# Rezoning Petition Review

**Date of Review:** October 21, 2004 (*Revised February 21, 2005*)

**Rezoning Petition #:** 04-136

**Location of Property:** Approximately 3.74 acres located east of the intersection of Moores Chapel Road and Belmeade Drive

### SHEET TITLE ILLUSTR. SITE PLAN SCHEME A

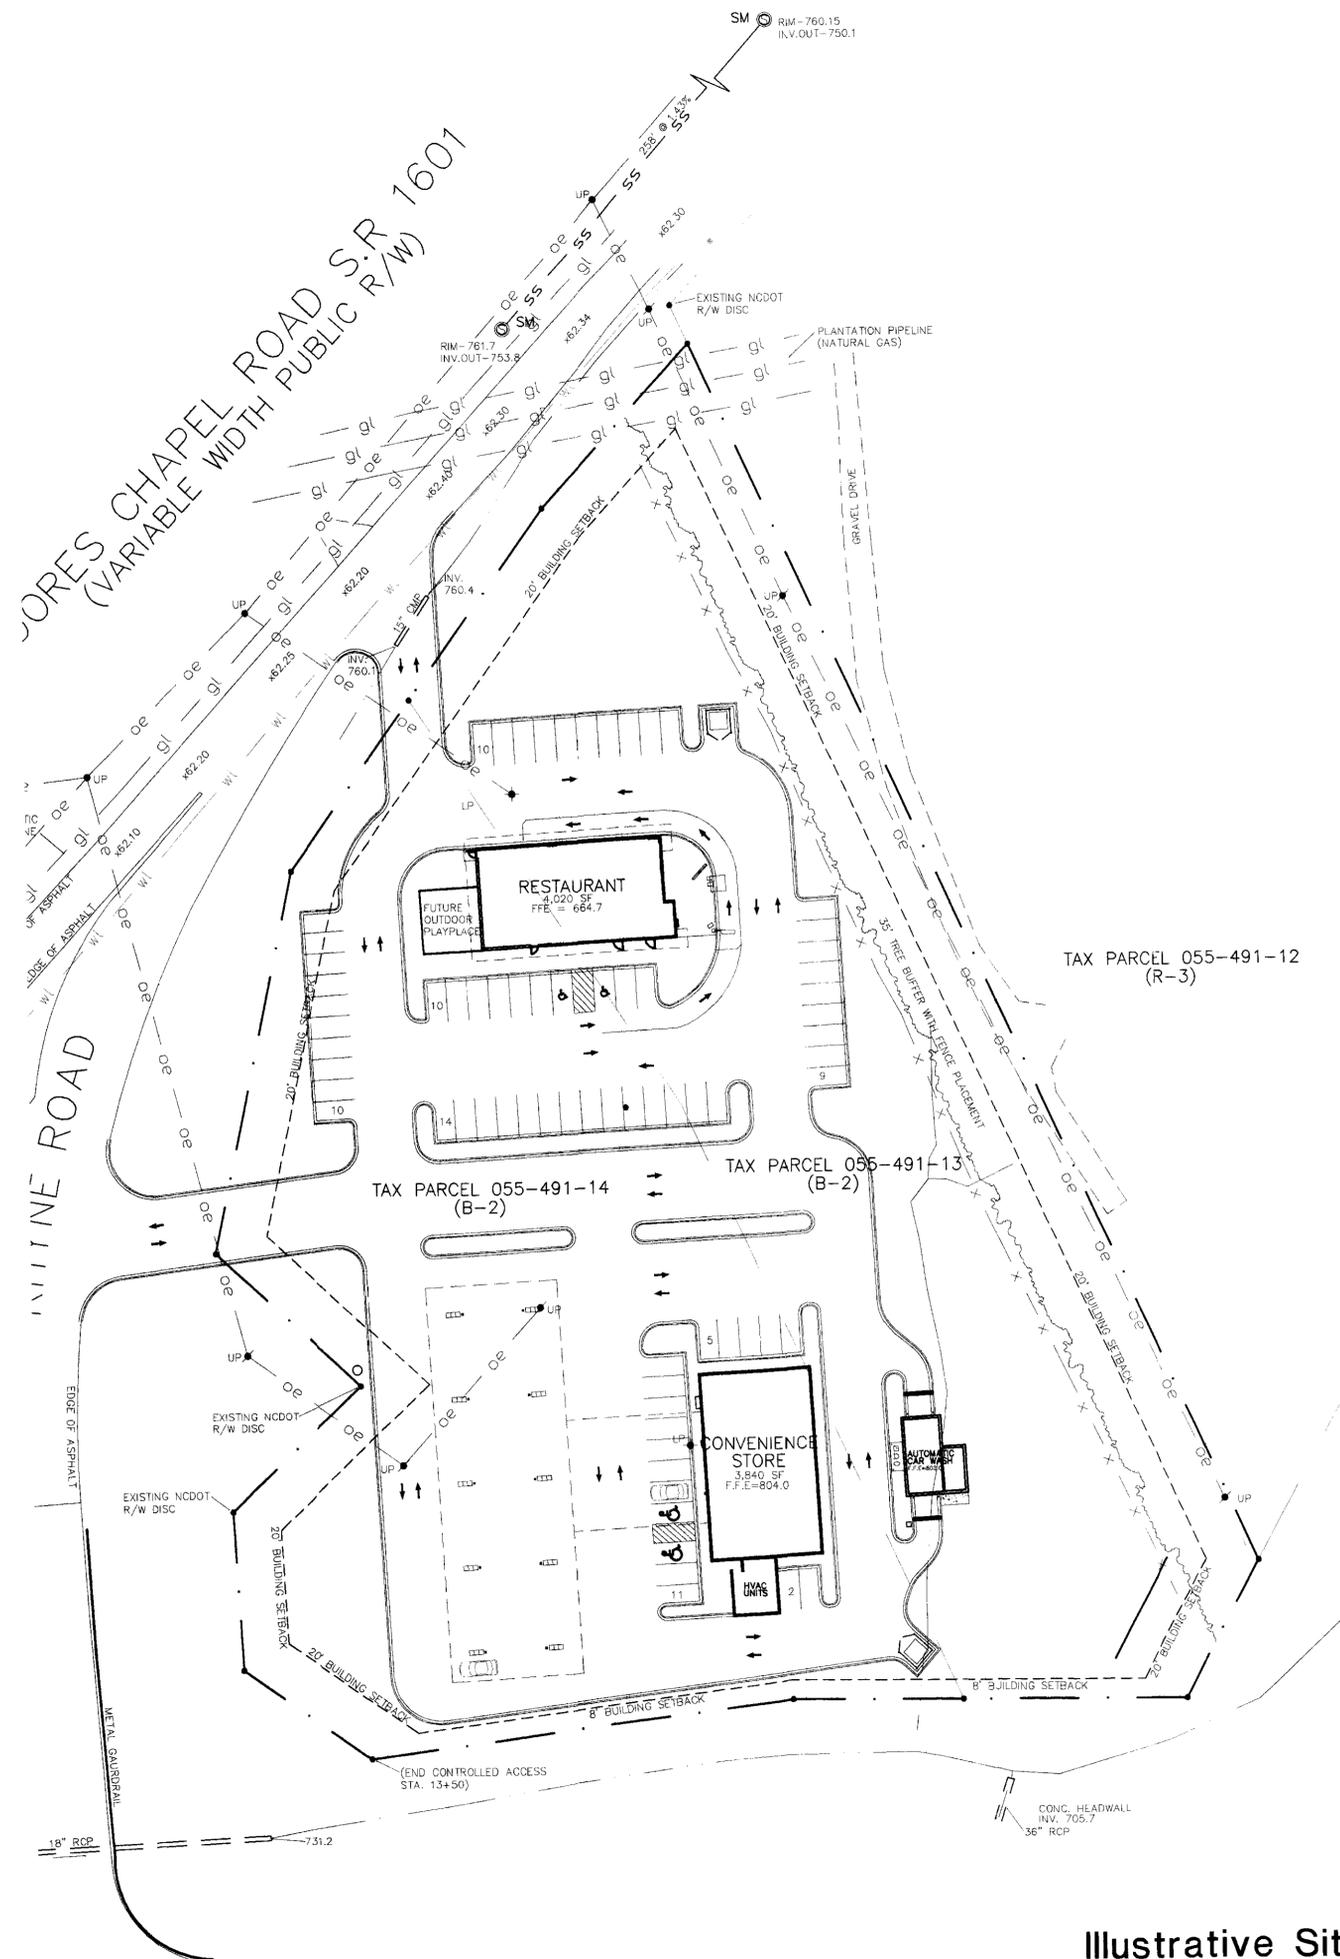
The petitioner shall tie-in to the existing storm water system(s). The petitioner shall have the receiving drainage system(s) analyzed to ensure that it will not be taken out of standard due to the development. If it is found that development will cause the storm drainage system(s) to be taken out of standard, the petitioner shall provide alternate methods to prevent this from occurring.

**ILLUSTR.
SITE /
LANDSCAPE
PLAN**

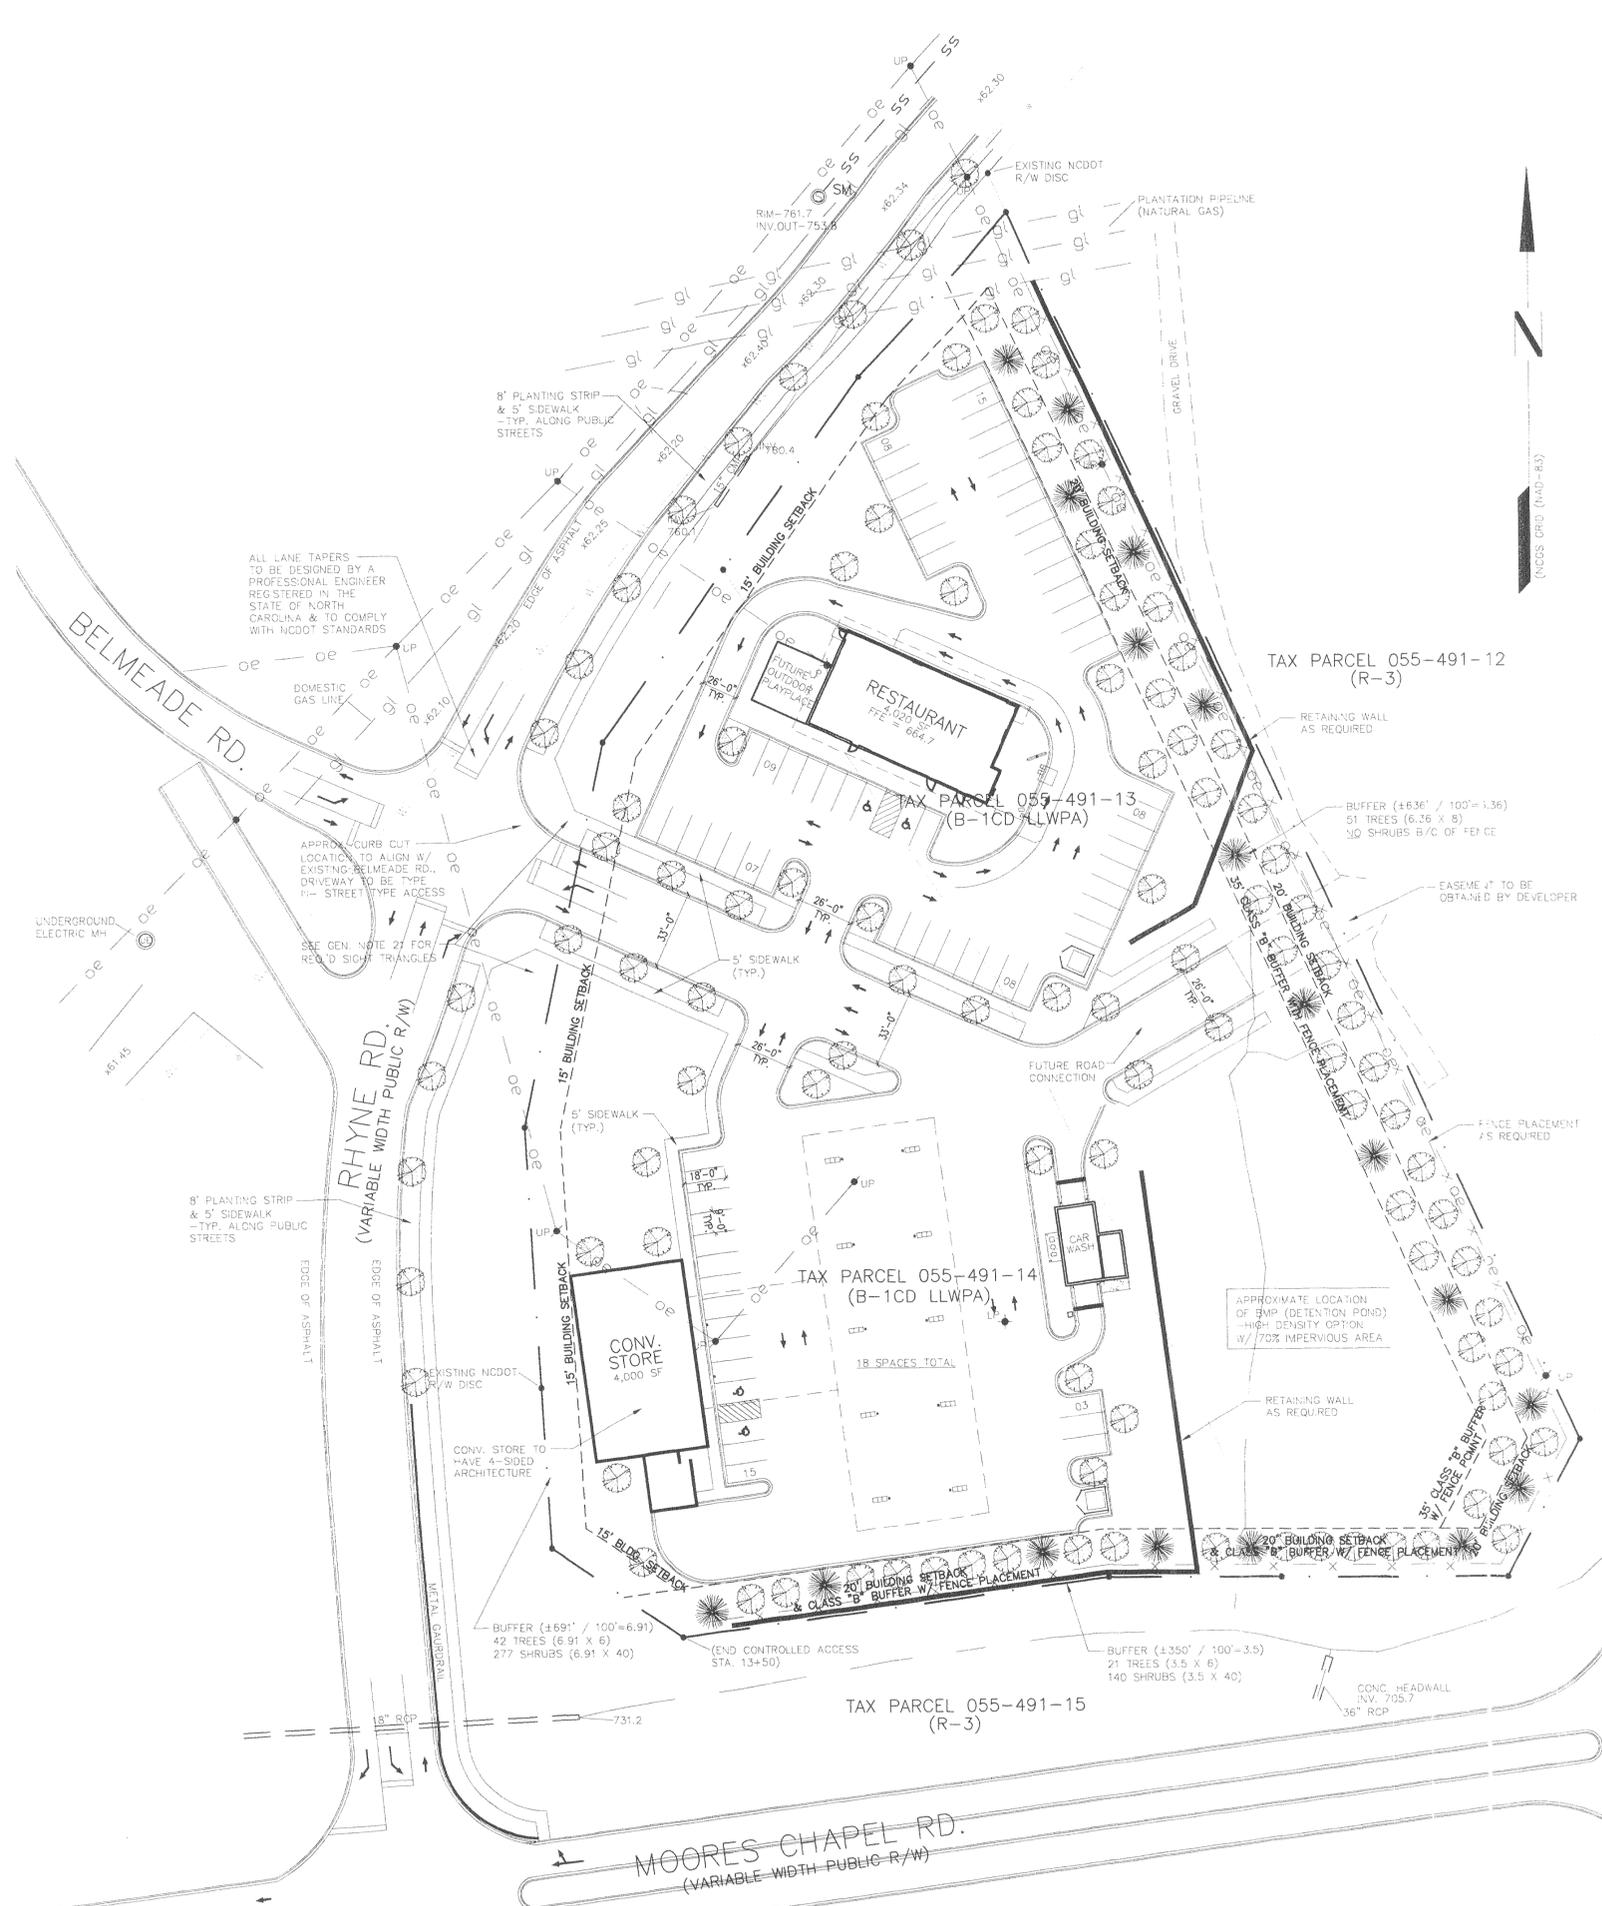
The petitioner shall tie-in to the existing storm water system(s). The petitioner shall have the receiving drainage system(s) analyzed to ensure that it will not be taken out of standard due to the development. If it is found that development will cause the storm drainage system(s) to be taken out of standard, the petitioner shall provide alternate methods to prevent this from occurring.
